Recommendation Report for Planning Permission for Works or Extension to a Dwelling

REF NO: EG/50/18/HH

LOCATION: 2 Como
Barnham Road
Eastergate
PO20 3RT

PROPOSAL: Demolition of double garage & erection of part one & two storey side extension.

Drawing
Proposed Arrangement
First Floor & Roof Plan

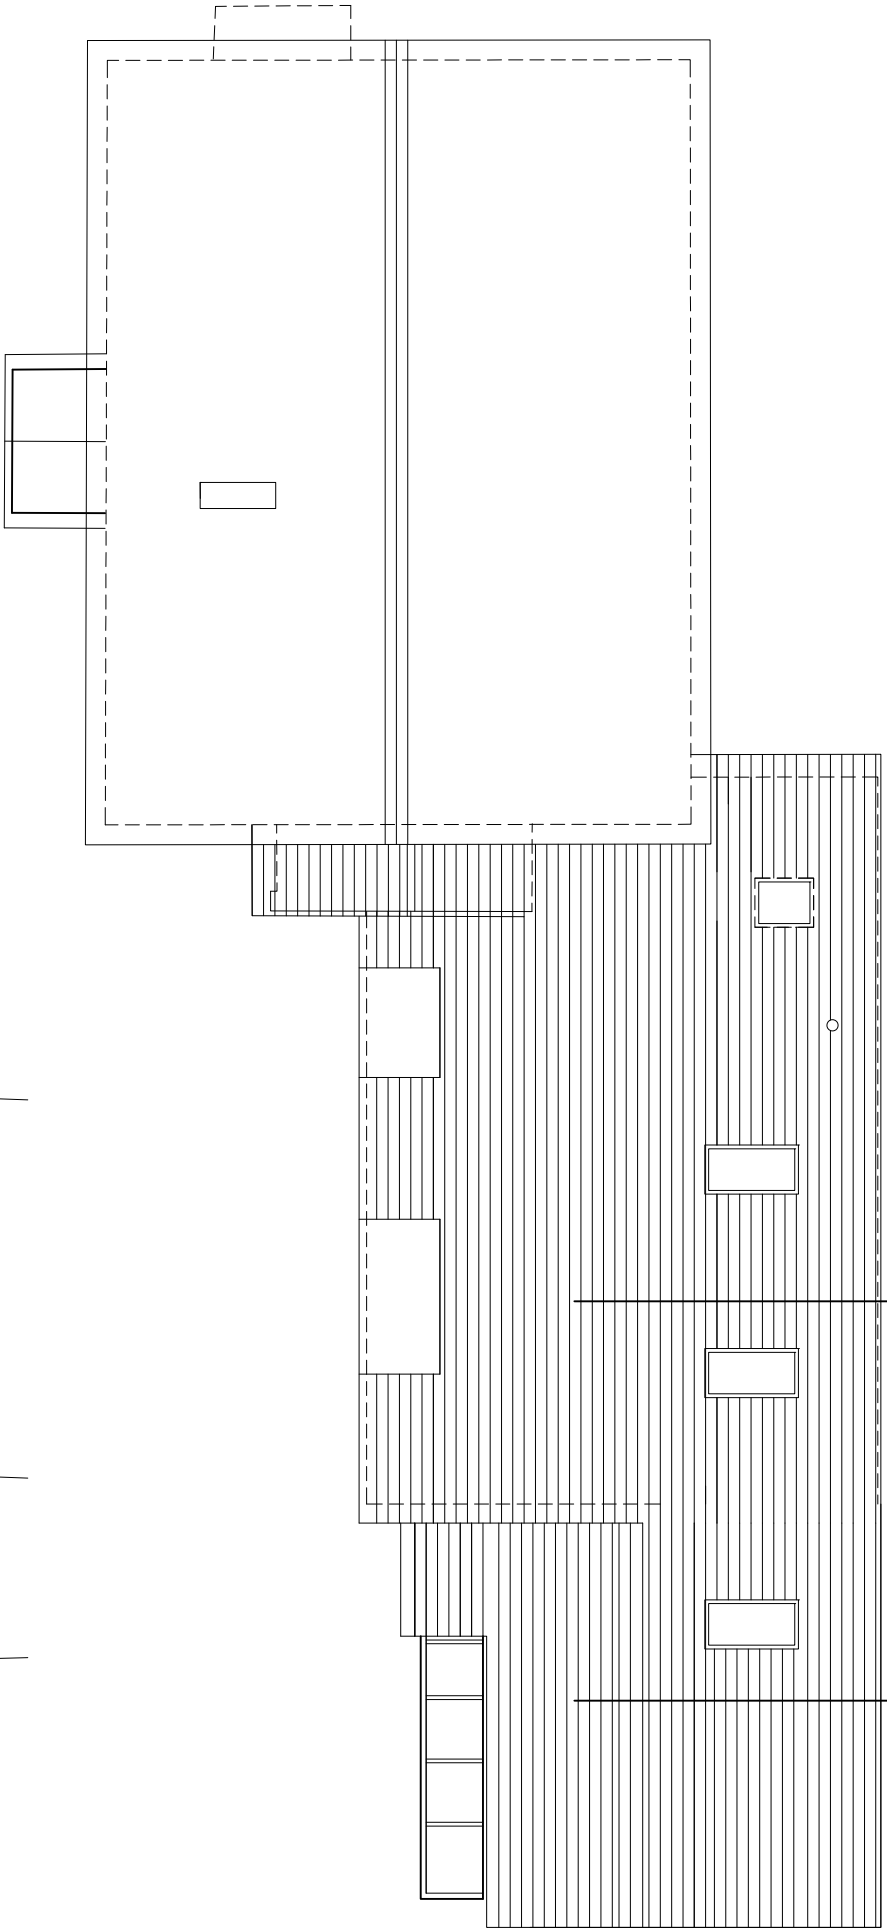
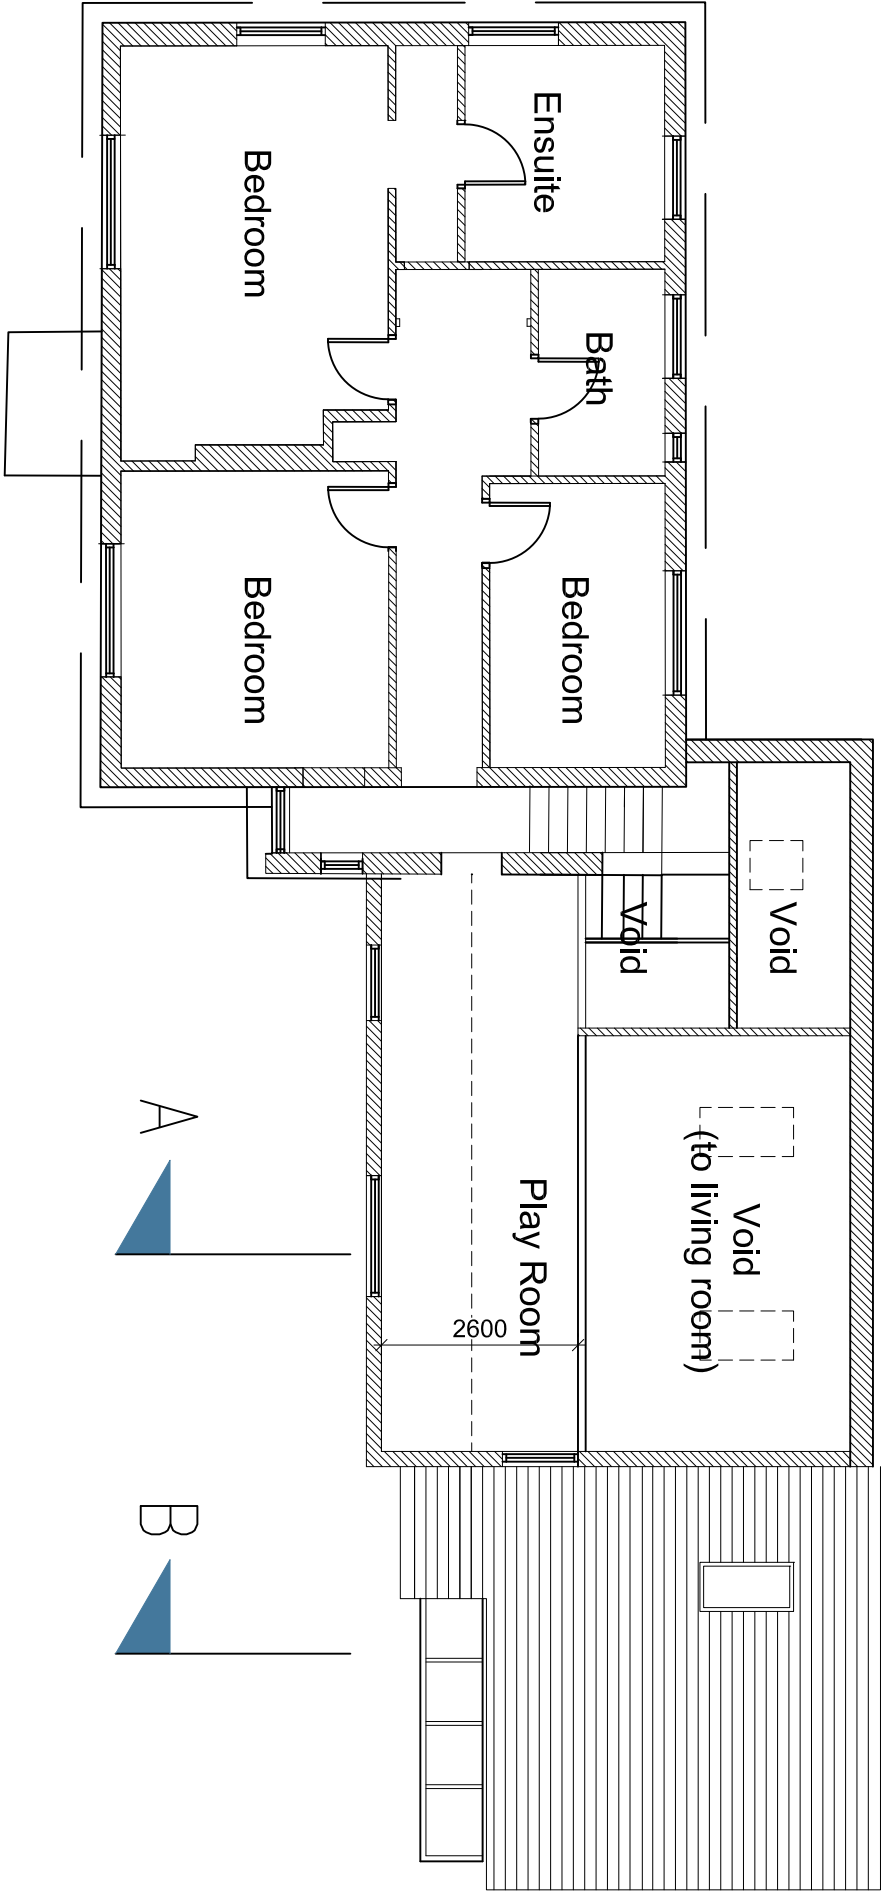
4 rooflights will also be installed along the two storey and single storey extension at the north western side however due to their location in terms of the height in that they are above 1.7m from the finished floor level they are not considered to give rise to any overlooking impacts and accord with DDM1 and DDM4 (c) of the Arun Local Plan.

Drawing
Proposed Arrangement
Elevations

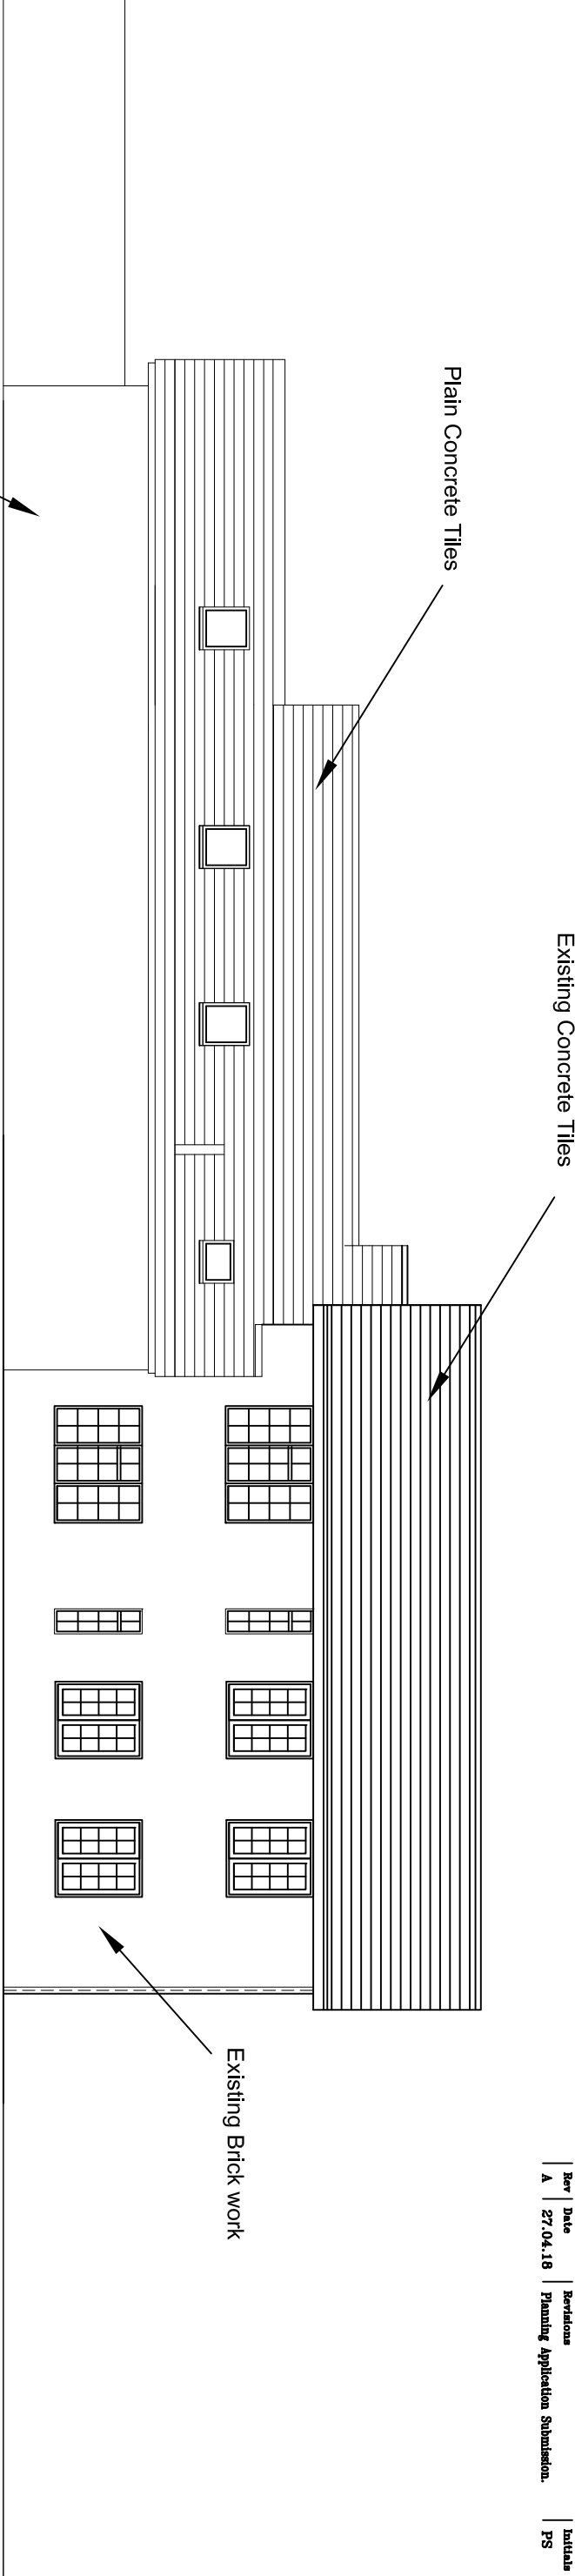
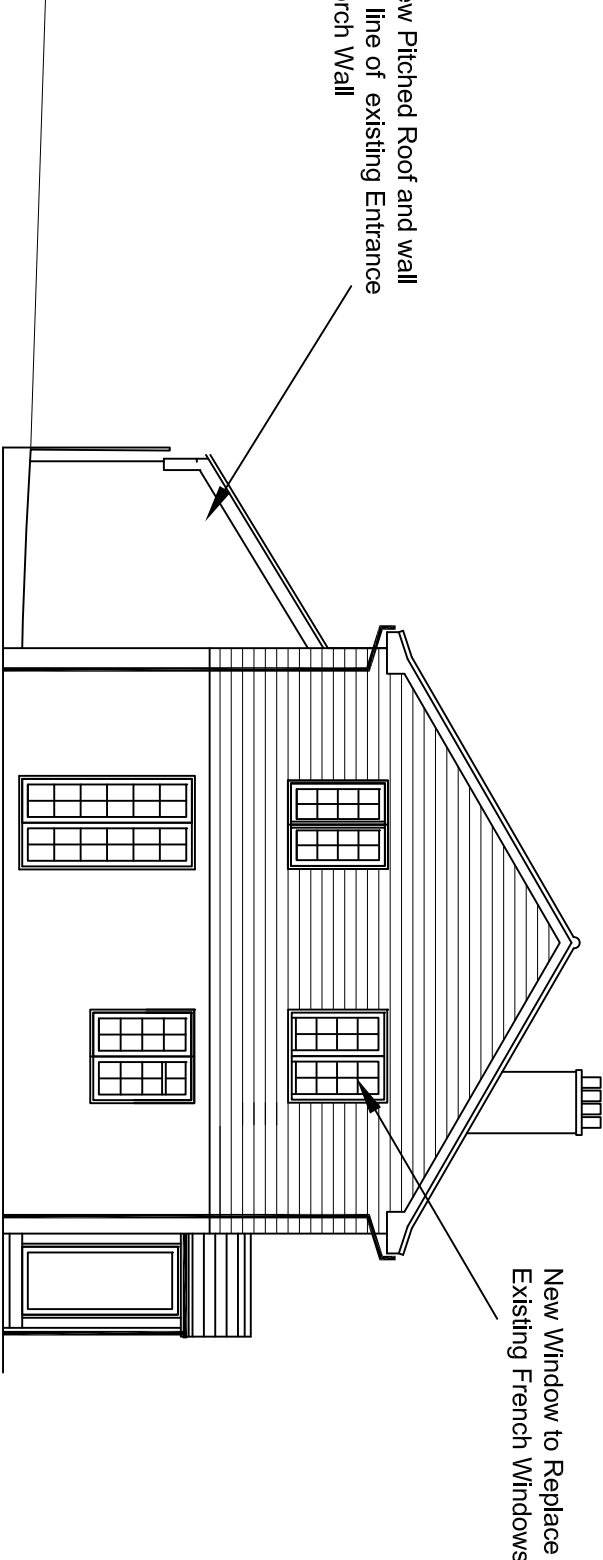
The maximum pitched roof height at the two storey extension will be around 5.5m approximately 1.9m below existing roof ridge of the host dwelling. The two storey element extends around 8m in length where the height then decreases to around 4.4m at the single storey element. This then extends a further 5m in length along the north east elevation.

Whilst the development is situated close to the boundary at the north west, the height of the extensions reduce as the development extends away from the host dwelling. Eaves height from the extensions along the boundary to No.18 are constructed at single storey level at around 2.2m in height sitting just above the fence line. The roof is therefore pitched away from the boundary with the roof design reducing its potential to give rise to any overbearing impacts upon the north western boundary. Due to the roof design and siting, it is not considered to give rise to any significant overbearing or to a loss of light that which a refusal could be justified.

There is currently an existing projection which provides staircase access to the first floor flat. This access will be re-sited to the front elevation of the new extension at the south east. 3 Additional windows will be located to this elevation with views over the driveway and front garden. Windows proposed to the north eastern elevation will overlook the rear garden which retains a minimum of 20m.

Client
Rosemary Burrow
Drawing Title
Surface Water Drainage

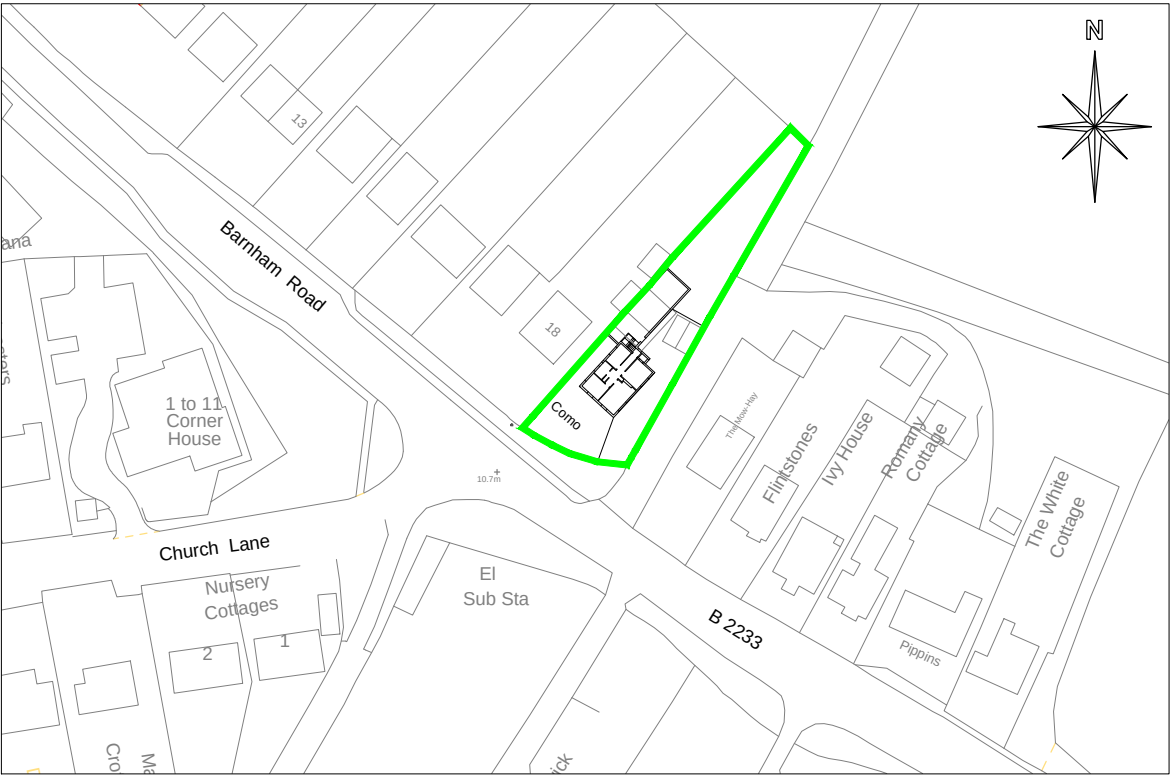
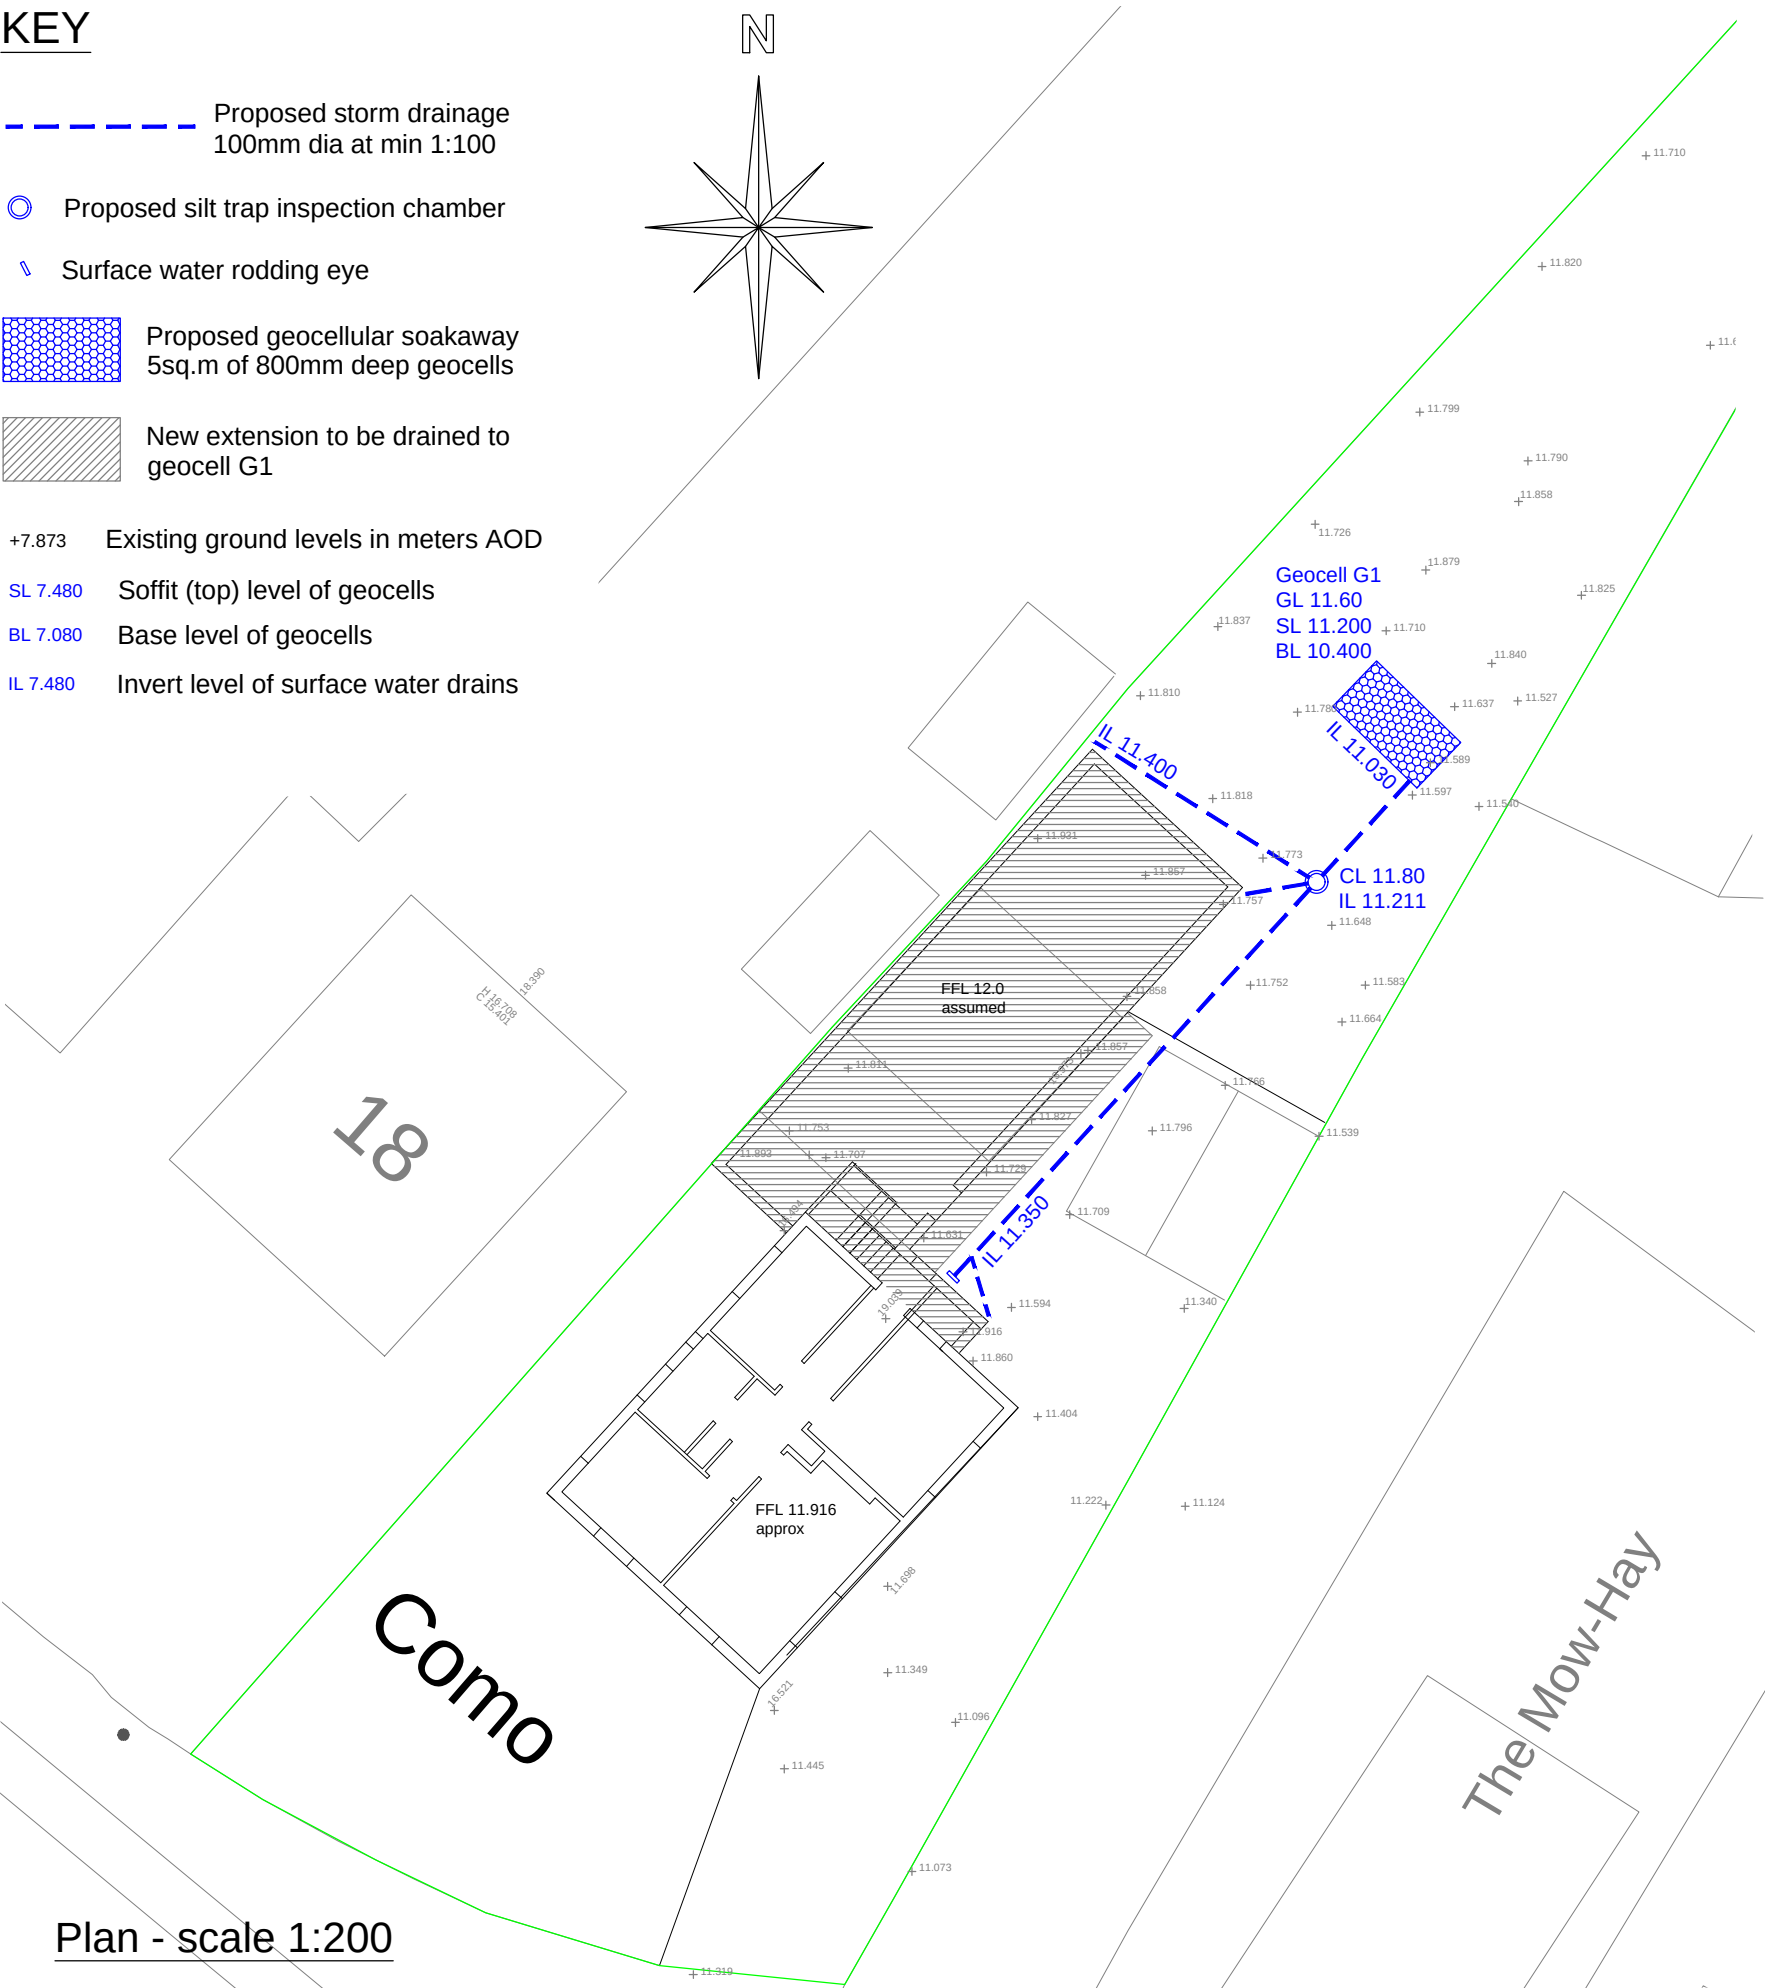
Drainage- Request a condition is imposed in such that the surface water drainage is constructed according to the supplied details.
